May 13, 2022

**Re: Peaks at Markana Phase 2 -  
Erosion and Sediment Control Plan  
Engineer's Stamp Date 4/29/2022 (E17E012)**

James D. Hughes, P.E.  
Principal Engineer, Planning Dept.  
Development and Review Services

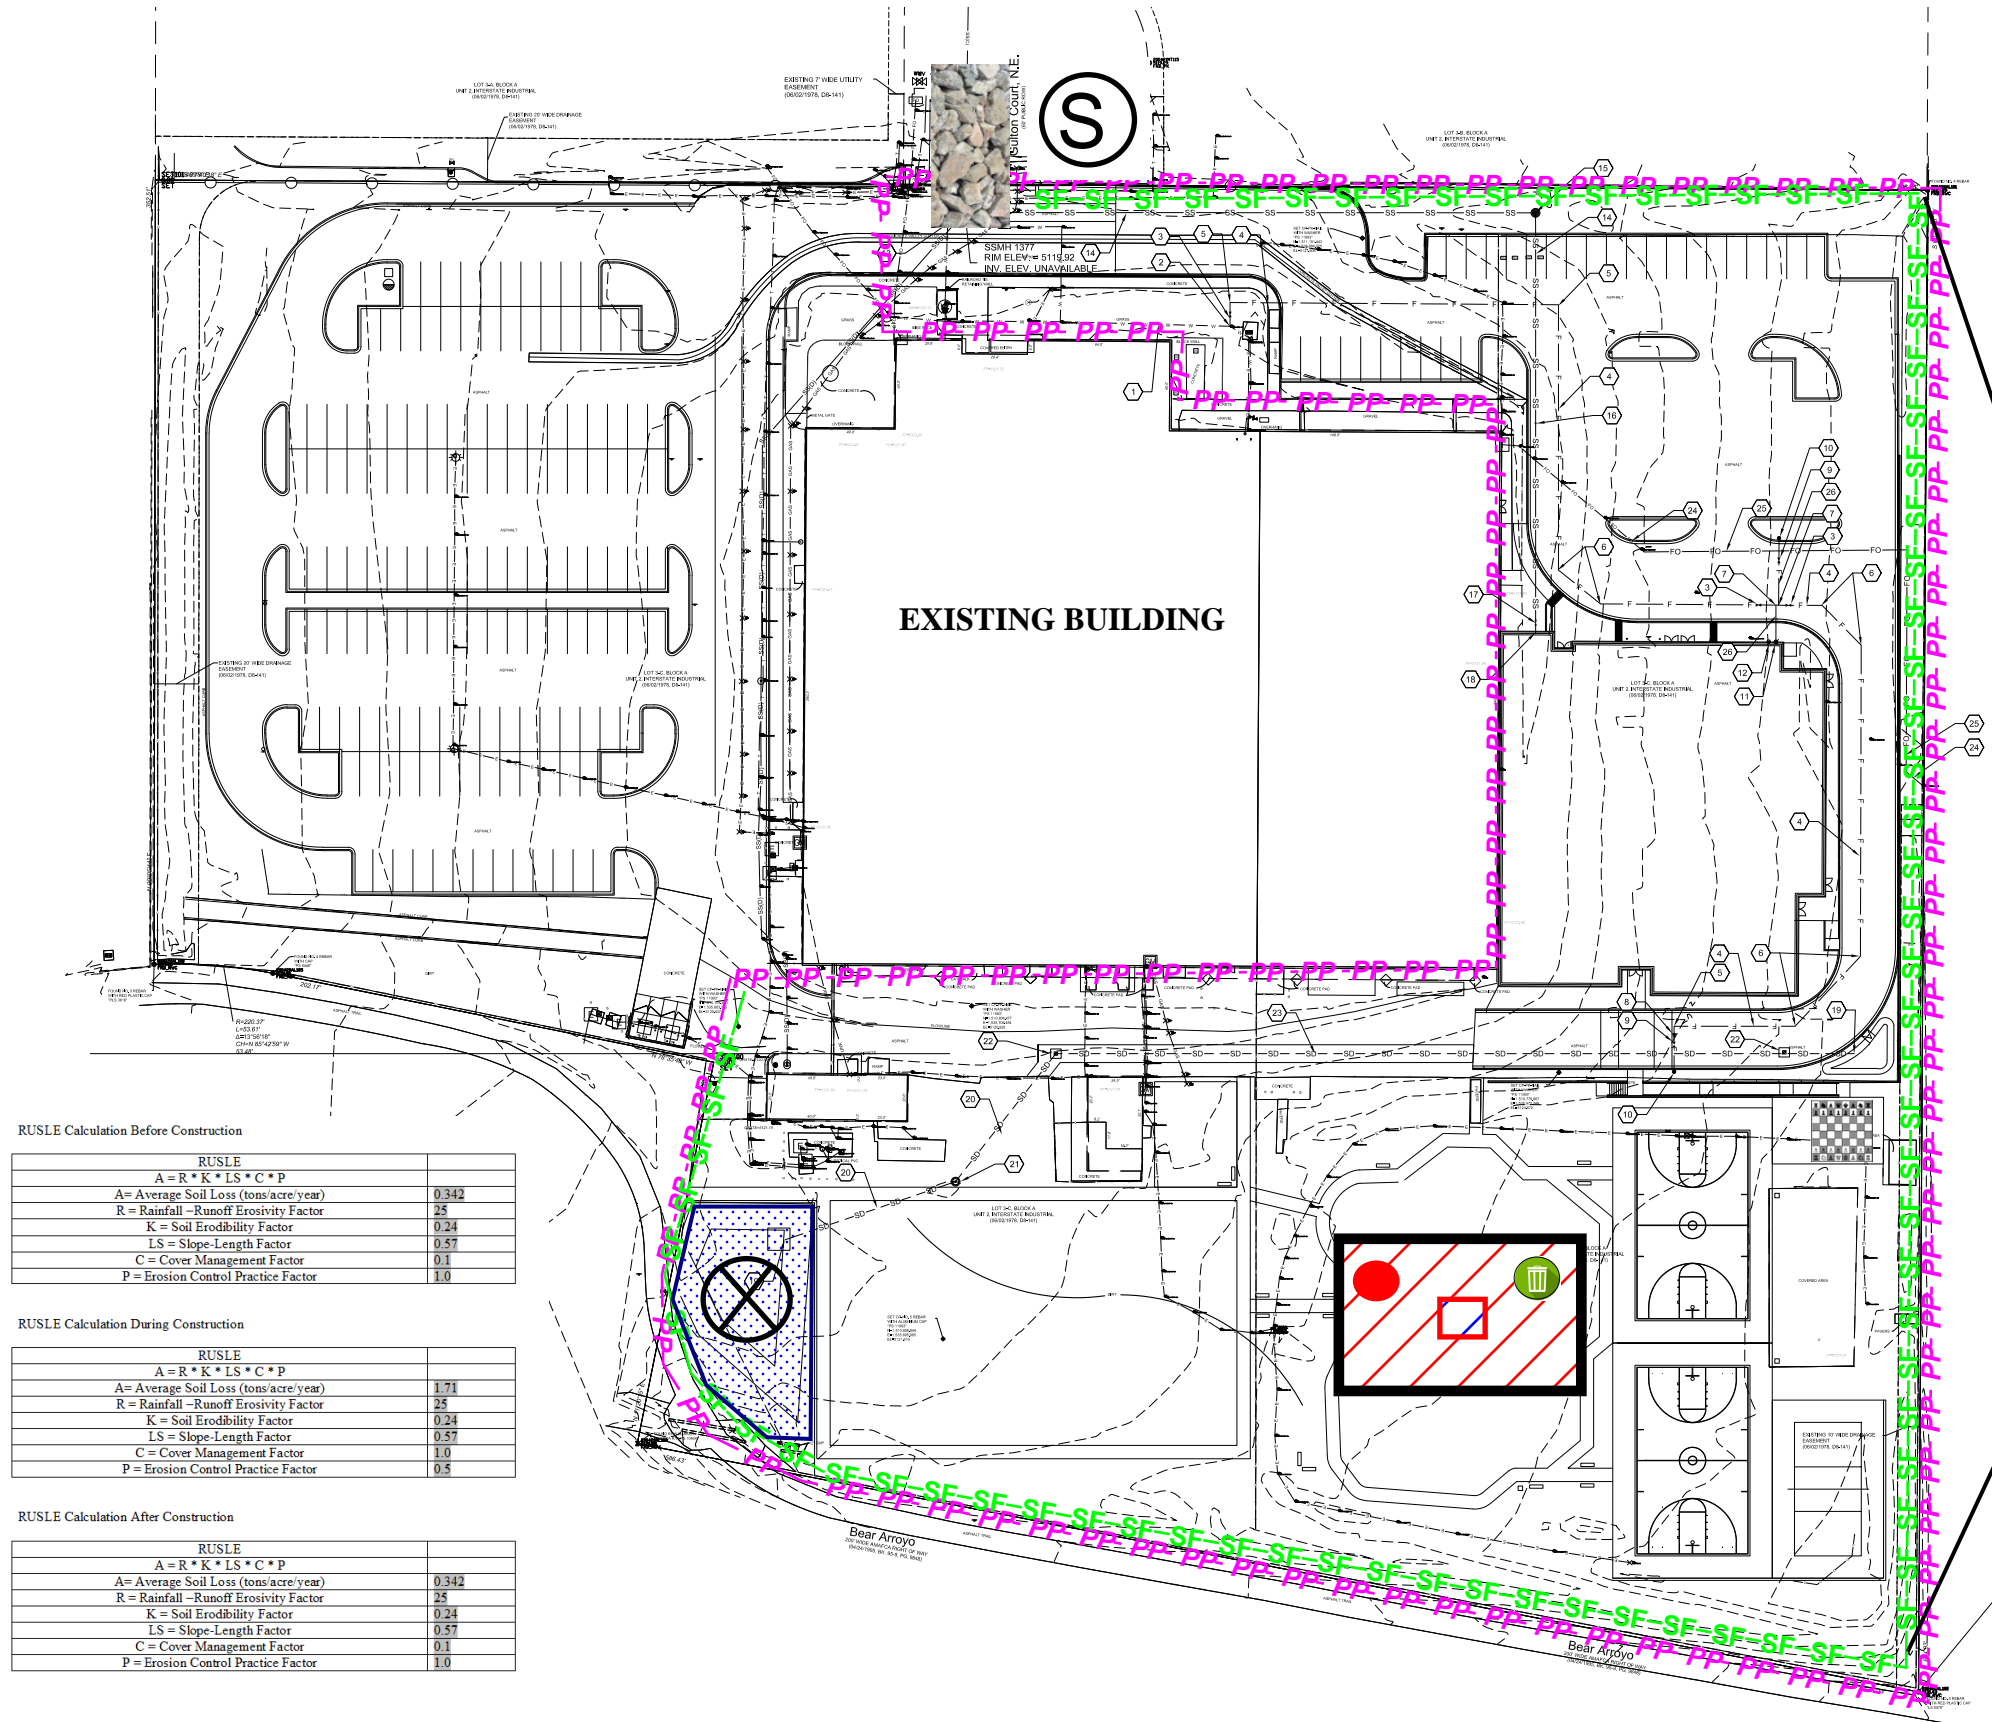
2. The ESC Plan can't be approved until after Hydrology approves the G&D Plan for each specific purpose; Building Permit, and Work Order. The only purpose Hydrology has approved so far is for DRB action which may include Rough Grading approval. The approved Conceptual G&D Plan has a "Preliminary Approval" stamp next to bold note that says not for construction. Further coordination with Hydrology is required before any land disturbing activities commence. The existing and proposed grades must be shown on the ESC Plan, and they must agree with the Grading Plan approved by Hydrology (CGP7.2.4.b.ii);

3. Stabilization measures (CGP 7.2.6.b.vi), including a) **Specific** vegetative and non-vegetative practices, b) deadlines, d) procedure to comply with The Weed Removal Ordinance (§ 9-8-1) must be identified. The landscape plan can be used to satisfy this requirement and should be included (on sheets separate from the ESC Plan) in the SWPPP and the ESC Plan submittal. Include specifications for the offsite areas of land disturbing activities as well.
4. Update the engineer's stamp date each time the plan is changed.
